Rezoning Transportation Analysis

Petition Number: #2022-110

| Date | Description |
|----------|-------------------|
| 11-27-22 | First Review (TM) |

SITE PLAN AND NOTES

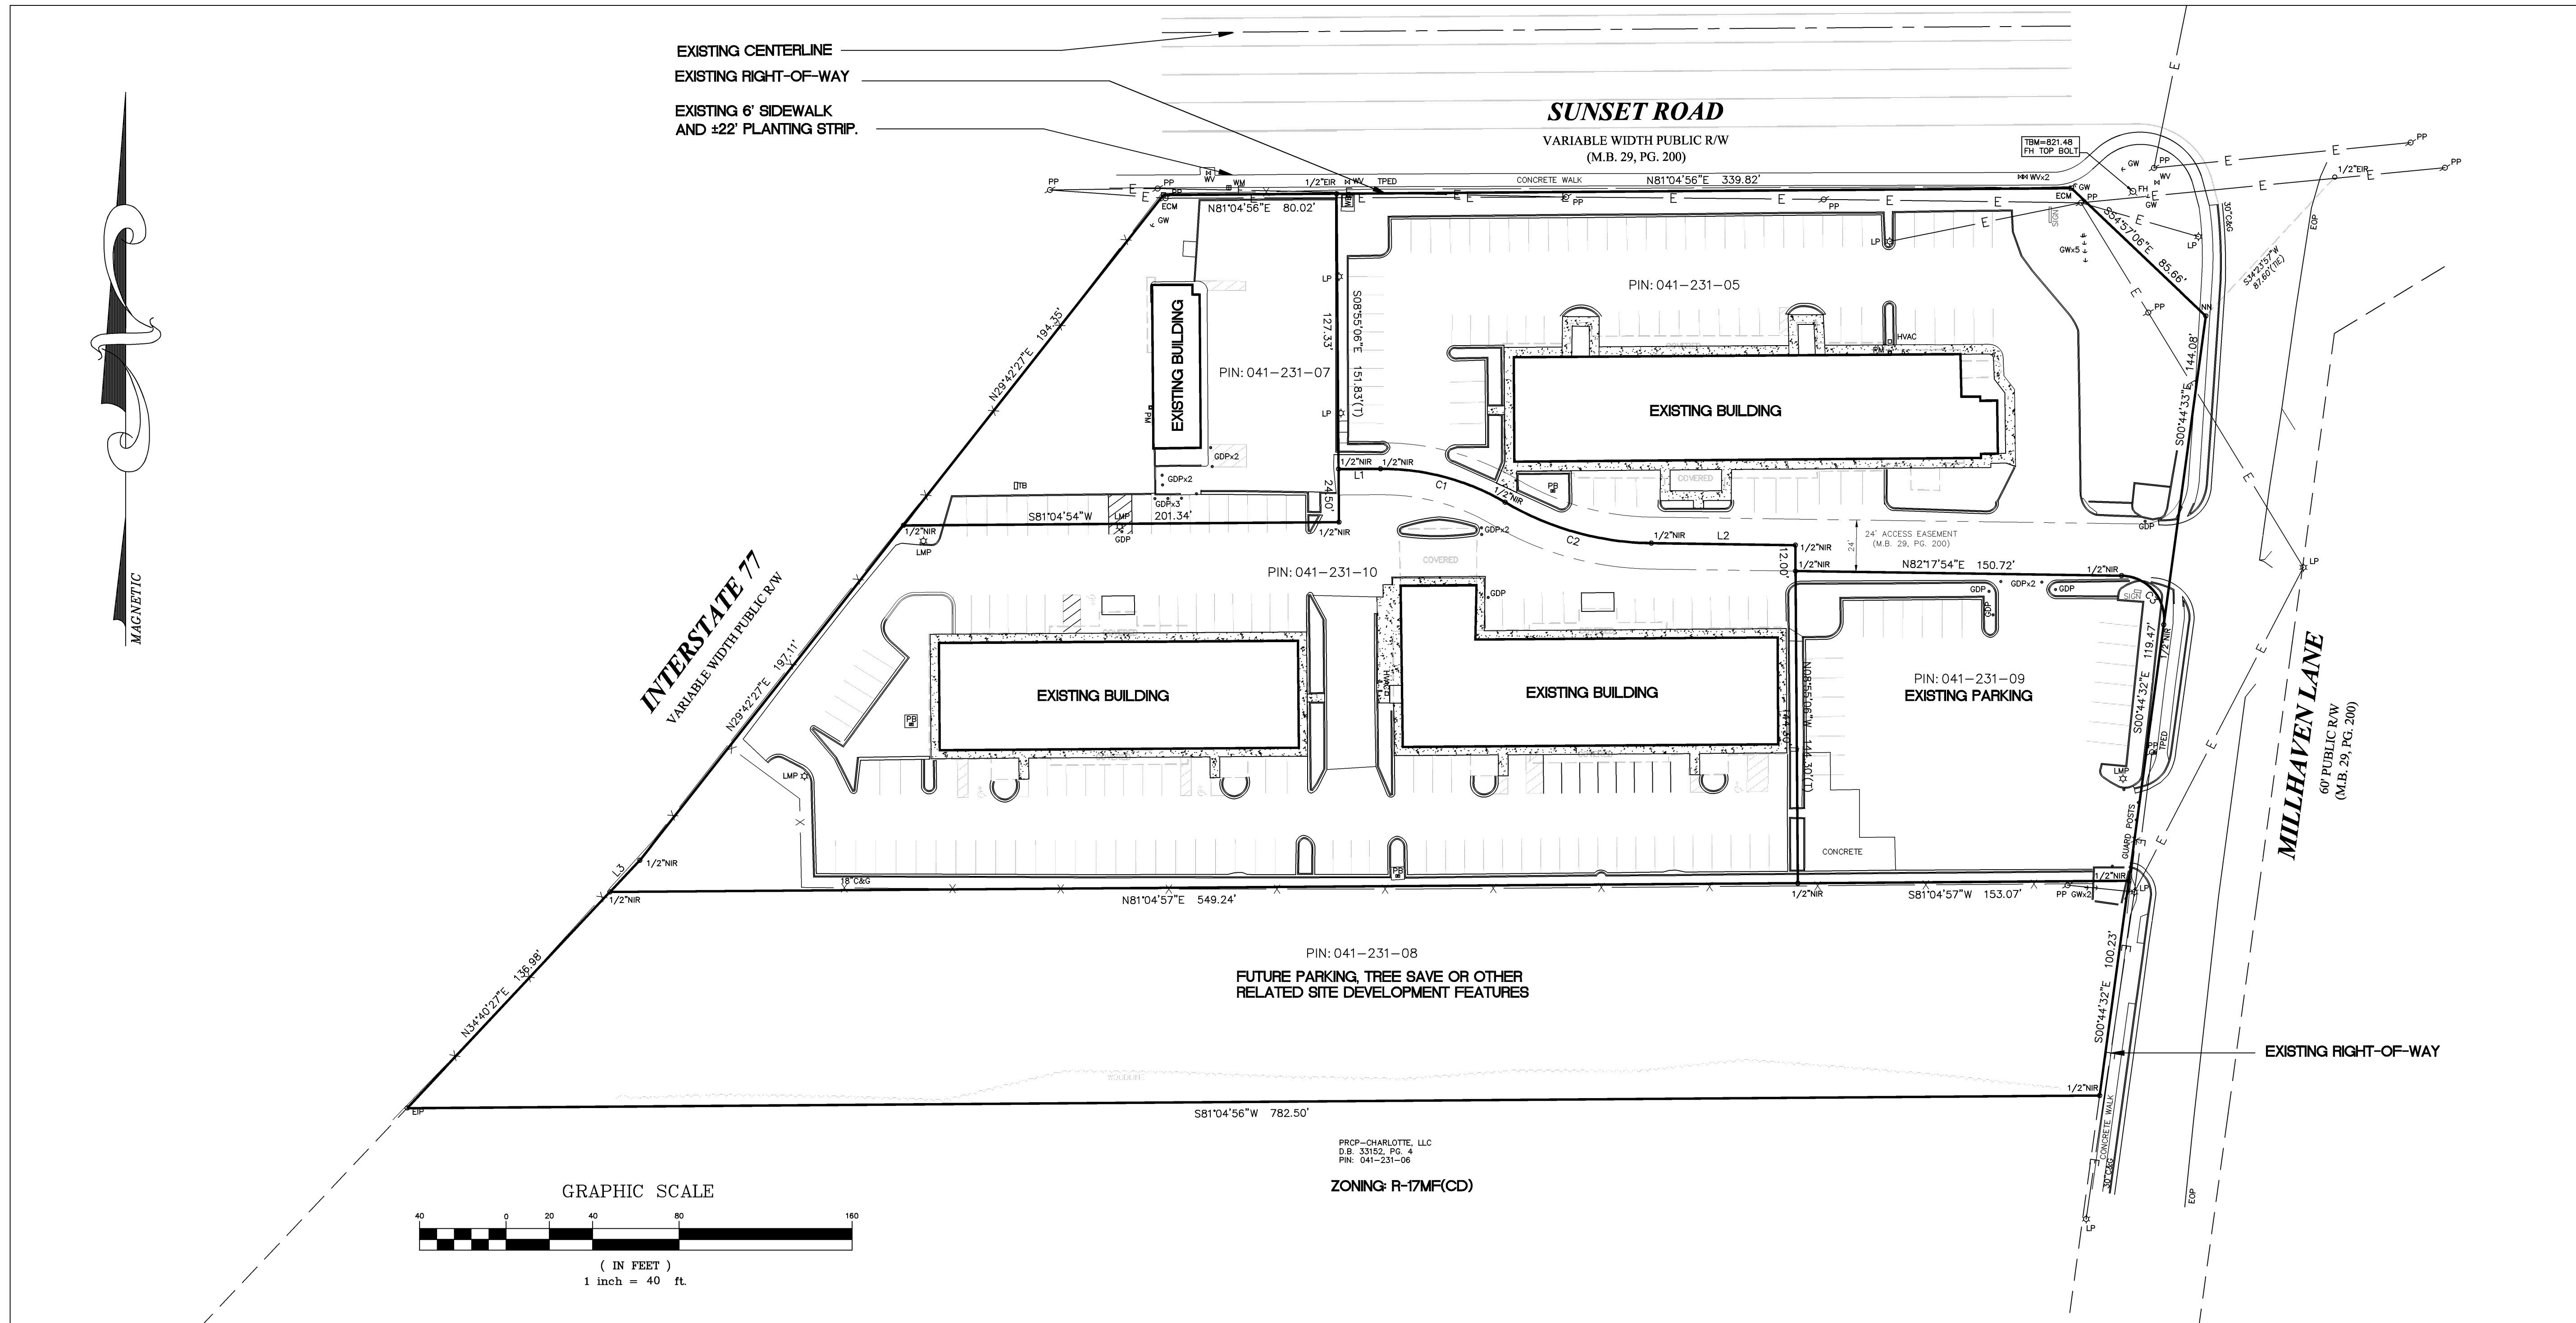
1. **Curbline:** The proposed zoning district has a setback measured from back of the existing or proposed future curbline.
 - a. **Sunset Road:** The future location of curb and gutter is located 33-feet from centerline to back of curb.
 - b. **Milhaven Lane:** The future location of curb and gutter is in its existing location.

Label and dimension the curb and gutter from the centerline for each road on the site plan.

3. Revise site plan and conditional note(s) to commit to dedicate 50-feet of right-of-way from the road centerline along Sunset Road. The site plan shall label and dimension the right-of-way from the road centerline.

4. Revise site plan and conditional note(s) to commit to dedicate 36-feet of right-of-way from the road centerline along Milhaven Lane. The site plan shall label and dimension the right-of-way from the road centerline.

5. Revise site plan and conditional note(s) to commit to construct an 8-foot planting strip, and 12-foot Multi-Use Path on Sunset Road per Chapter 19. The site plan shall label and dimension both items from the back of curb and gutter and road centerline.

6. Revise site plan and conditional note(s) to commit to construct an 8-foot planting strip, and 8-foot sidewalk Millhaven Lane per Chapter 19. The site plan shall label and dimension both items from the back of curb and gutter and road centerline.

7. Site plan and conditional note(s) revisions are needed to commit to construct bicycle facilities by locating the curb and gutter 33-feet from the center line and installing a 12' multi-use path to meet the City Charlotte BIKE Policy along Sunset Road.

8. CDOT REQUEST that Site plan and conditional note(s) revisions are made to commit to repaving Milhaven road at the southern site entrance.
